City of Albuquerque
Stormwater Construction Site
Inspection Report

| Project Name and Location | Legacy Home Healthcare 3610 Bosque Lane NW | | |

Describe Present Phase of Construction: Constructing bldg

EROSION AND SEDIMENT CONTROL PLAN

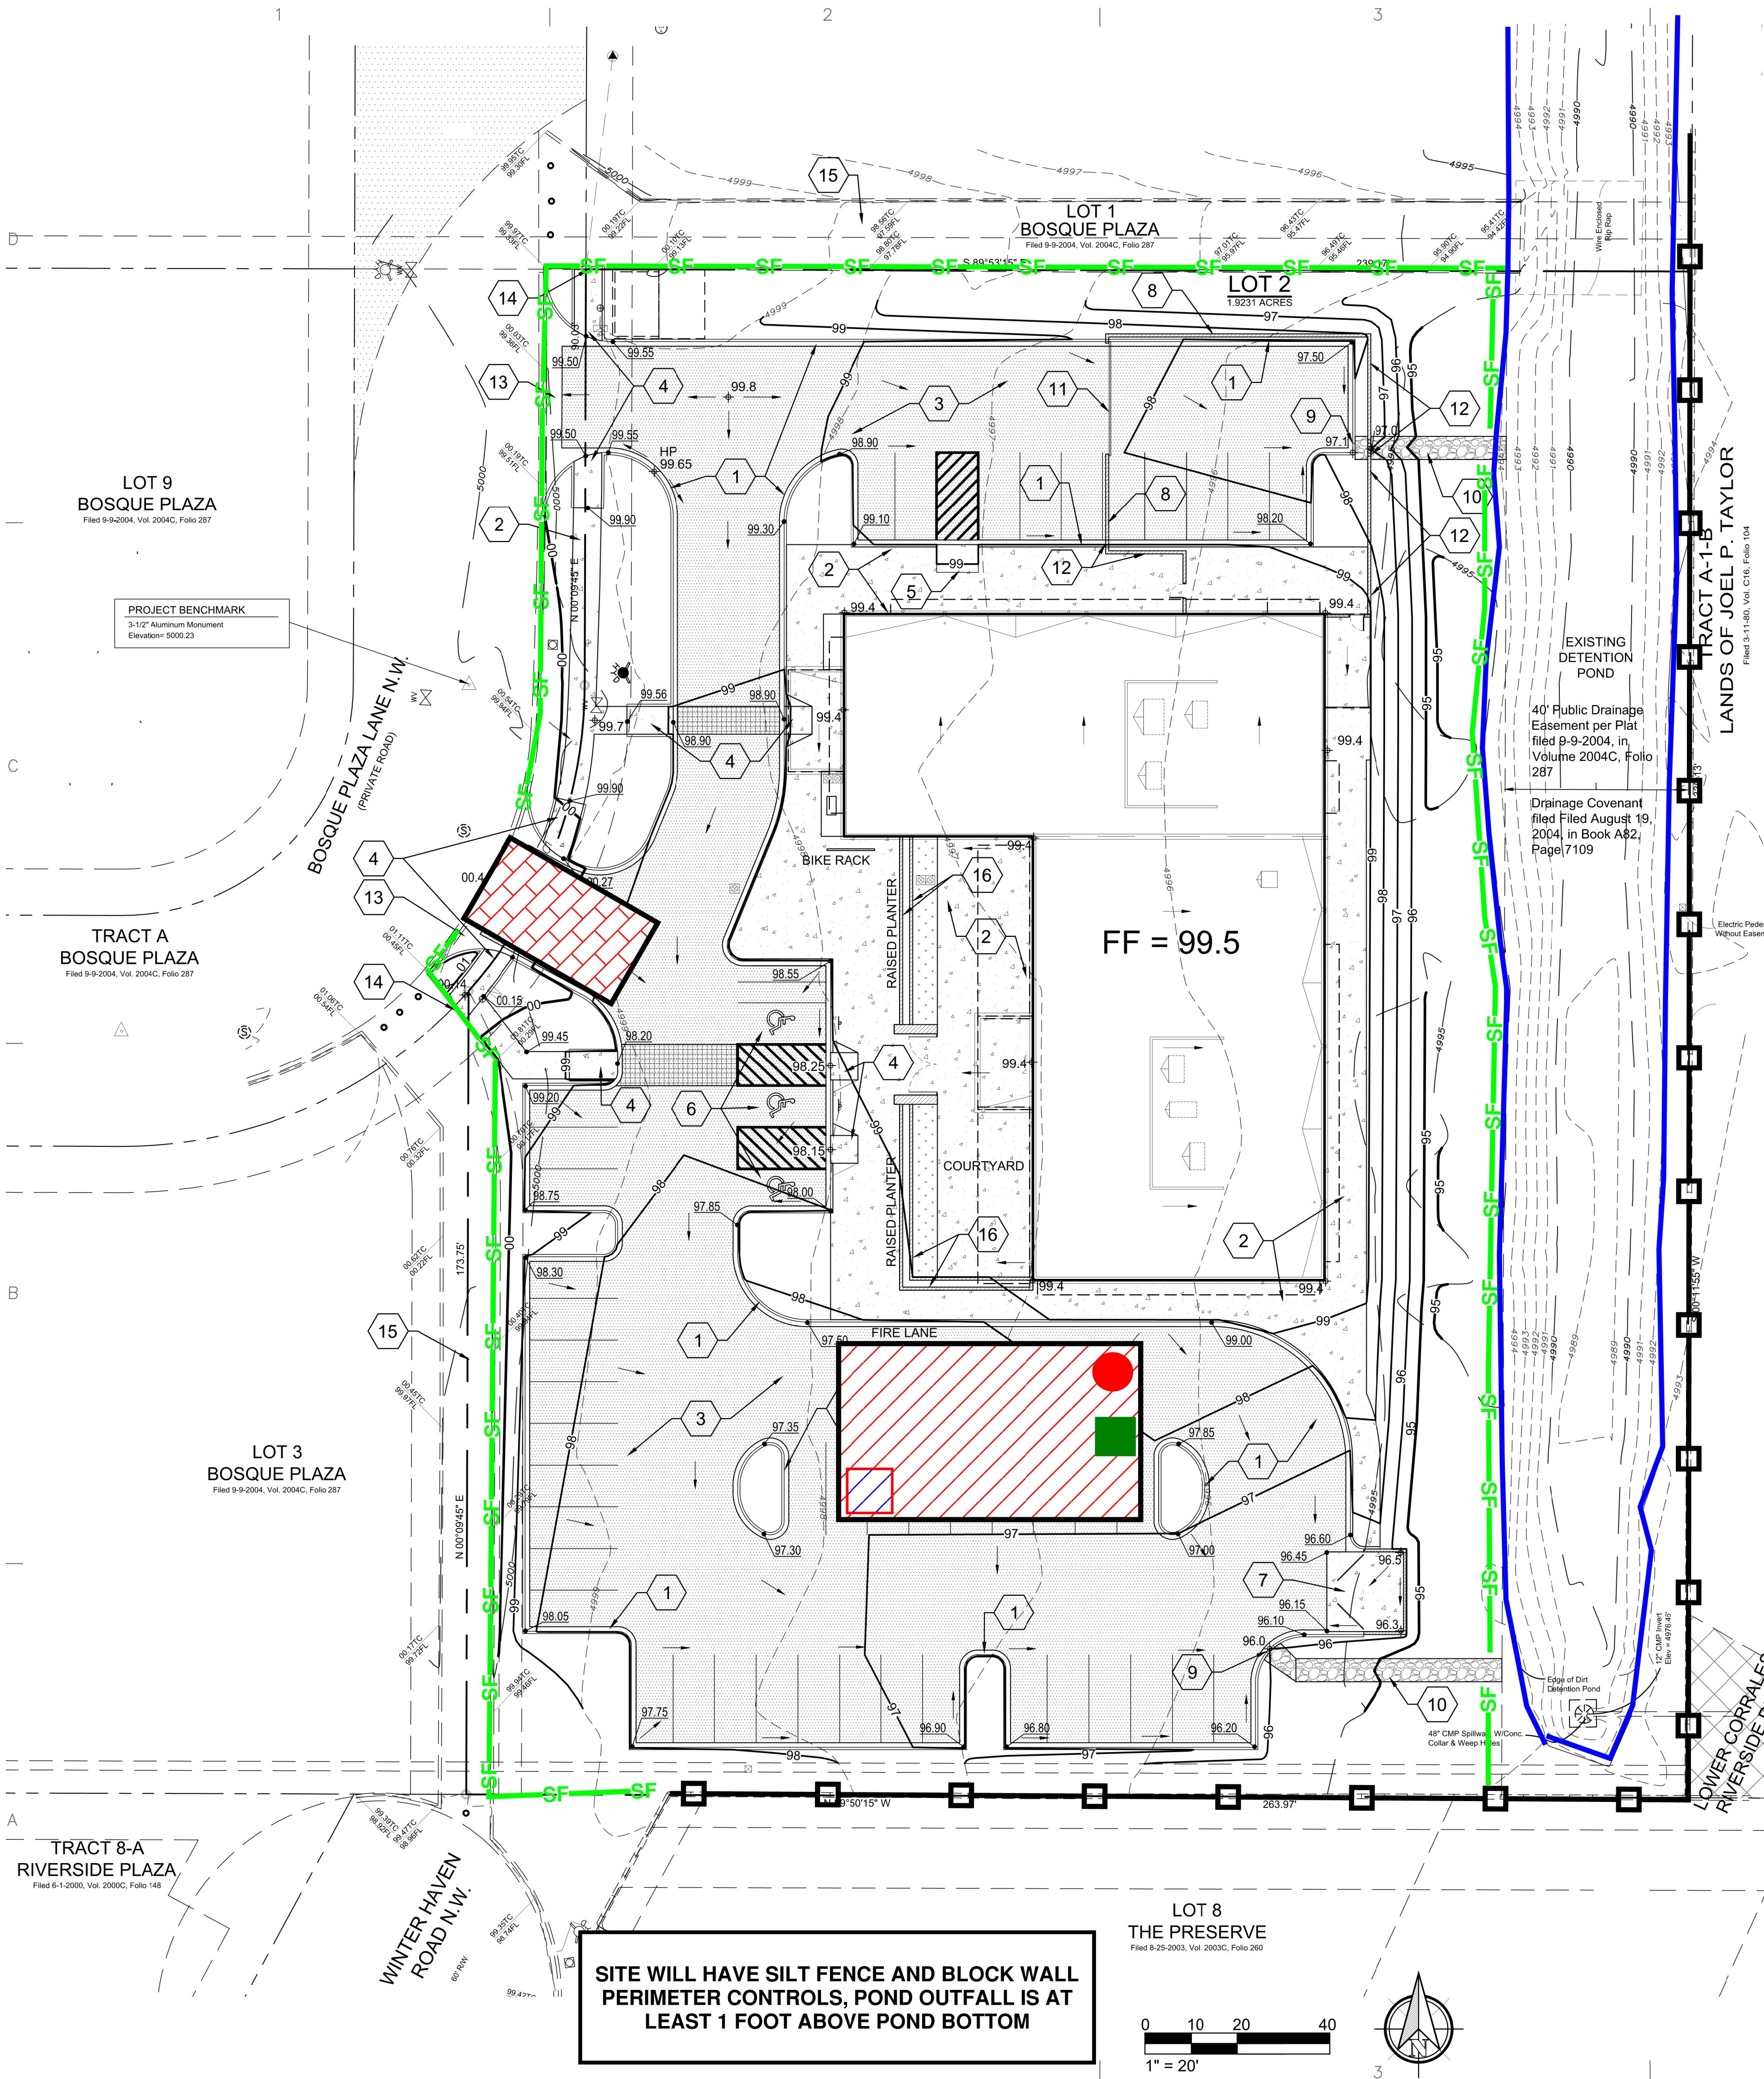
| CGP ¹ Section | BMP / Activity | Maintenance or Corrective Action Required | Location and Notes |
|--------------------------|---|---|----------------------------------|
| 2.2.3 | Sediment control along any perimeter | ✓ | Silt fence maintenance east side |

| 2.3.3 | Construction and Domestic Wastes | ✓ | trash east side and in pond |
| 2.3.4 | Washing Applicators used for paint, stucco, concrete, etc. | ✓ | wash-out |

Maintenance or corrective actions are to be completed within 7 days.
